DRAWN BY: O.E. WATTS	APPROVED BY:	REVISIONS	OLIVER E. WATTS CONSULTING ENGINEER COLORADO SPRINGS	PROJECT 16140 OLD DENVER ROAD PART NW1/4 SEC. 26, T.11S., R.67W, 6TH P.M. EL PASO COUNTY	SHT. NAME CONSTRUCTION DOCUMENT COVER SHEET	SHT. NO. 1 OF 3	
	DATE: 10-23-19	PROJ. NO.						
	DWG. NO.: 17-4958-06	DWG.

DRAWN BY: D.E.WATTS	APPROVED BY:	REVISIONS 1-18-21 REVISED PER COUNTY COMMENTS	DEW	OLIVER E. WATTS CONSULTING ENGINEER COLORADO SPRINGS	PROJECT 16140 OLD DENVER ROAD PART NW1/4 SEC. 26, T.11S., R.67W. 6TH P.M. EL PASO COUNTY	SHT. NAME CONSTRUCTION DOCUMENT GRADING AND EROSION CONTROL PLAN	SHT. NO. 2 OF 3	
	DATE: 10-28-19	PROJ. NO.							
	DWG. NO.: 17-4958-04	DWG.	1-21-19 ADD EASEMENT	DEW					
	SURVEYED BY: DEW, ES, 10-24-16, J-24-17, A-18-19		10-23-19 REVISED PER COUNTY COMMENTS	DEW

DRAWN BY: O.E. WATTS	APPROVED BY:	REVISIONS 5-15-20 REVISED PER COUNTY REVIEW COMMENTS DEW	OLIVER E. WATTS CONSULTING ENGINEER COLORADO SPRINGS	PROJECT 16140 OLD DENVER ROAD PART NW1/4 SEC. 26, T.11S., R.67W. 6TH P.M. EL PASO COUNTY	SHT. NAME CONSTRUCTION DOCUMENT EROSION CONTROL DETAILS	SHT. NO. 3 OF 3	
	DATE: 10-23-19	PROJ. NO.	1-18-20 REVISED PER COUNTY REVIEW COMMENTS DEW					
	DWG. NO. 17-4958-0

OUTLET WORKS PROFILE
1/2"=1'-0"

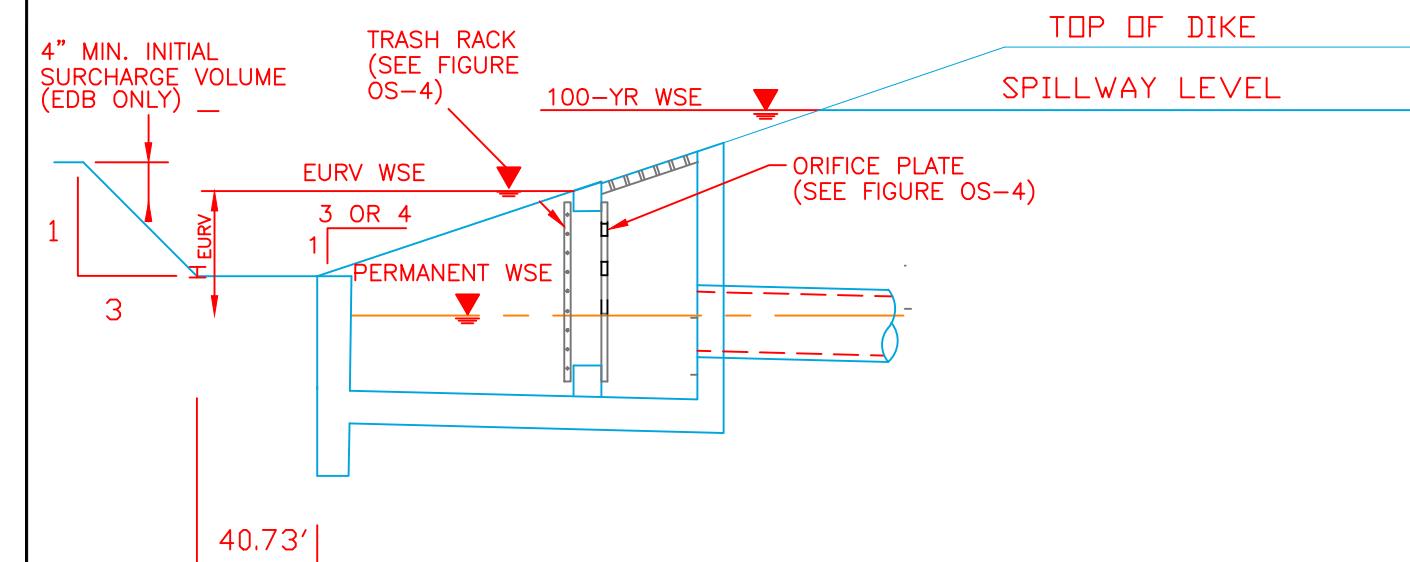
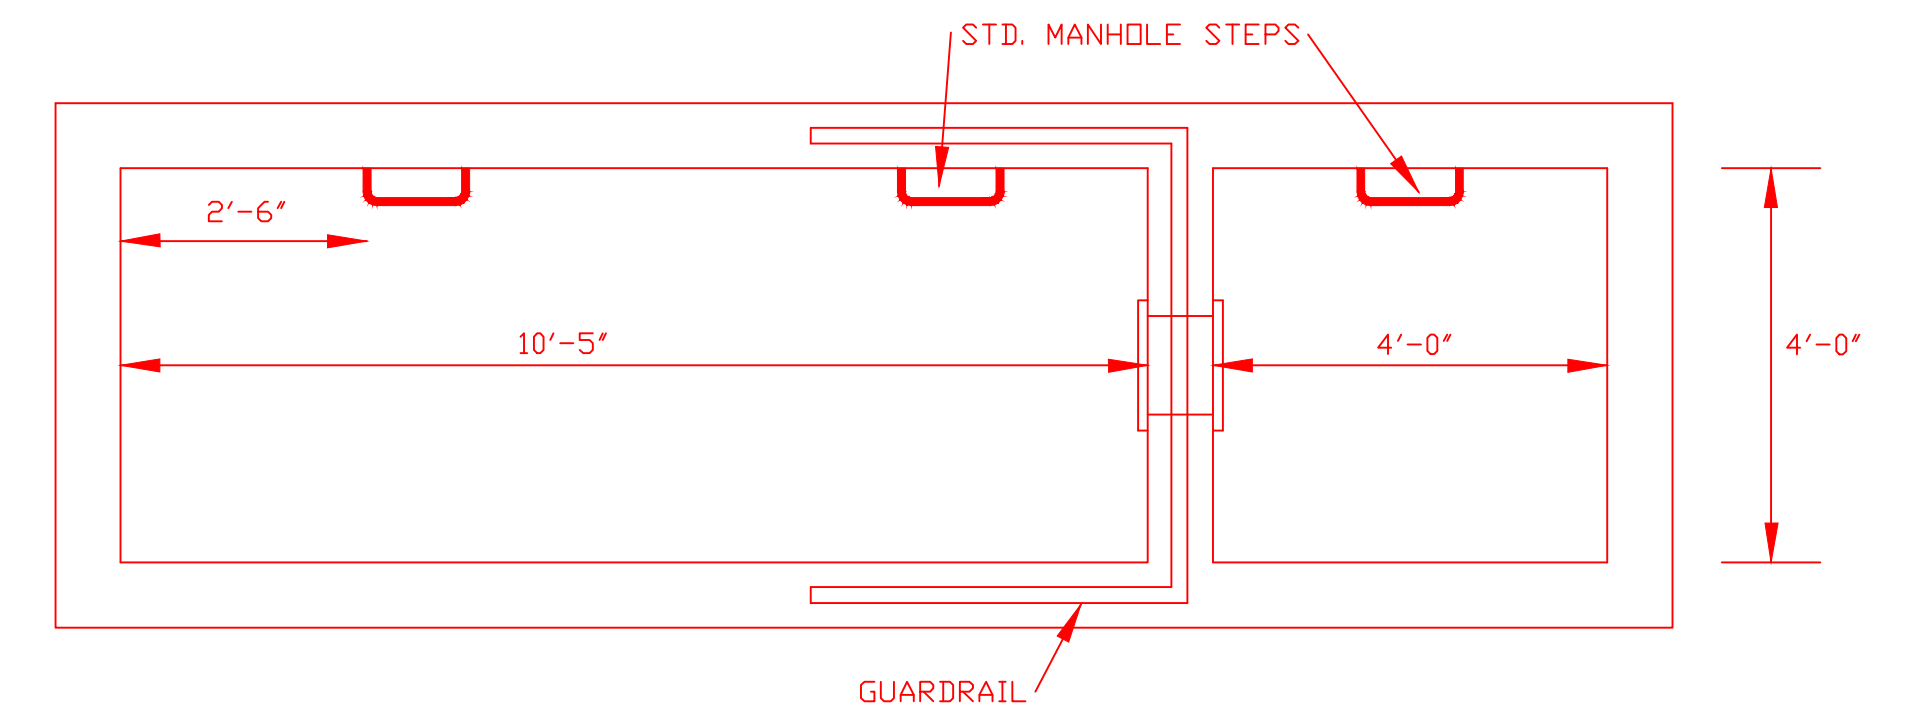
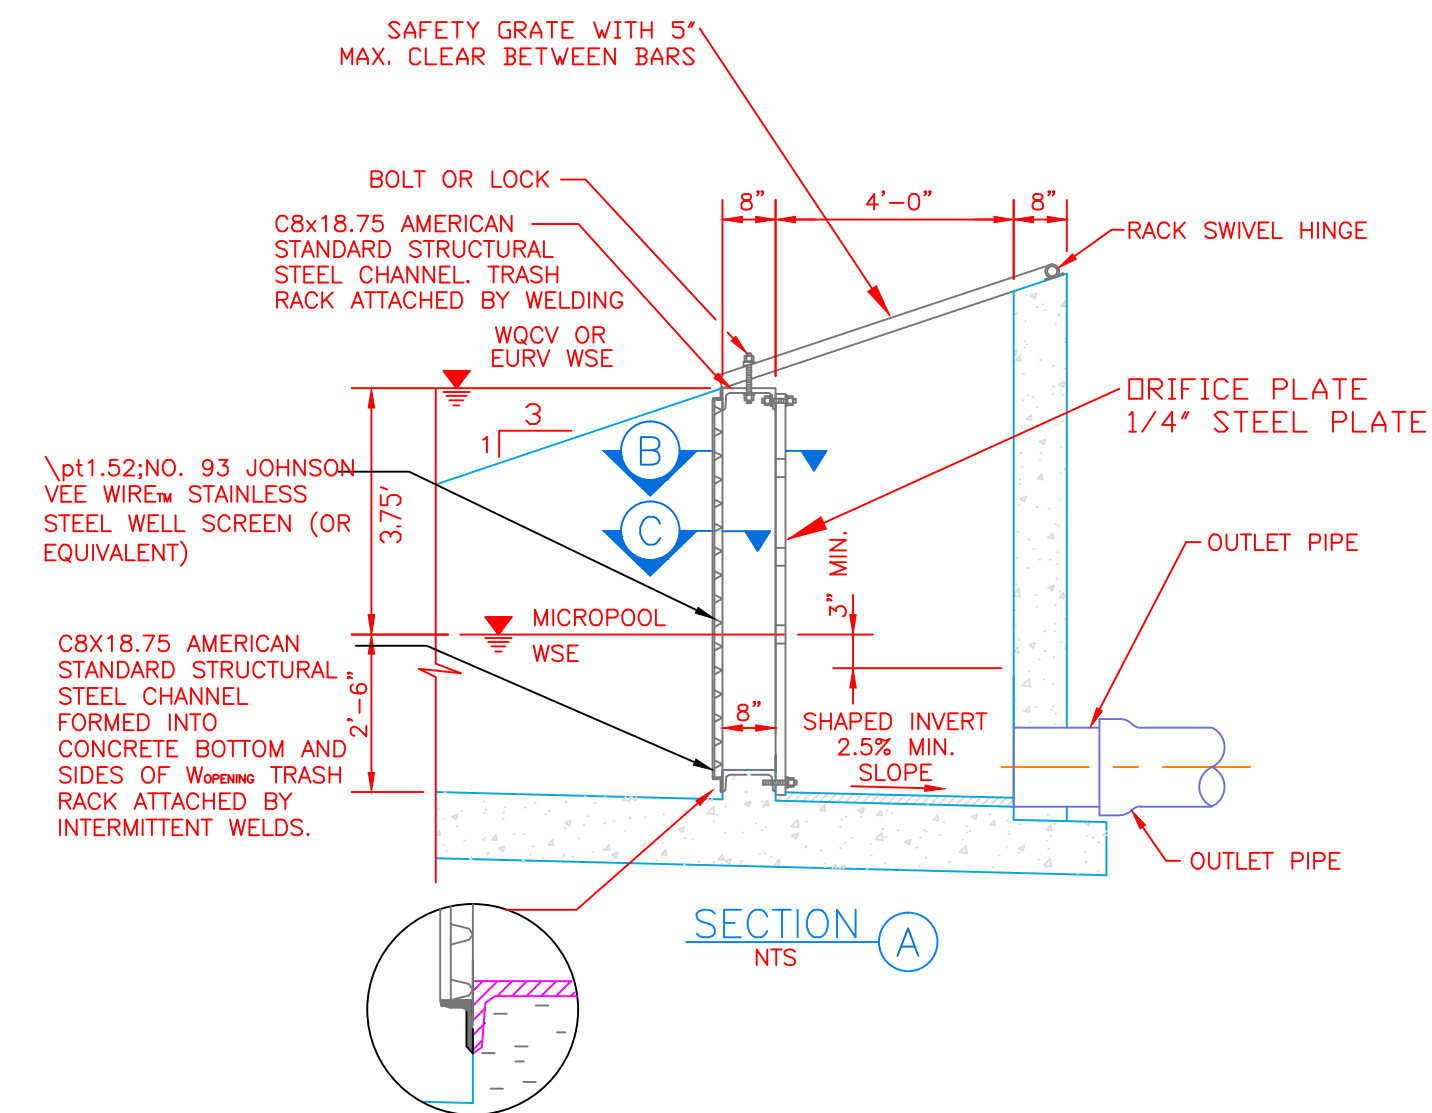
Extended Detention Basin outlet structure detail is missing from the construction drawings.
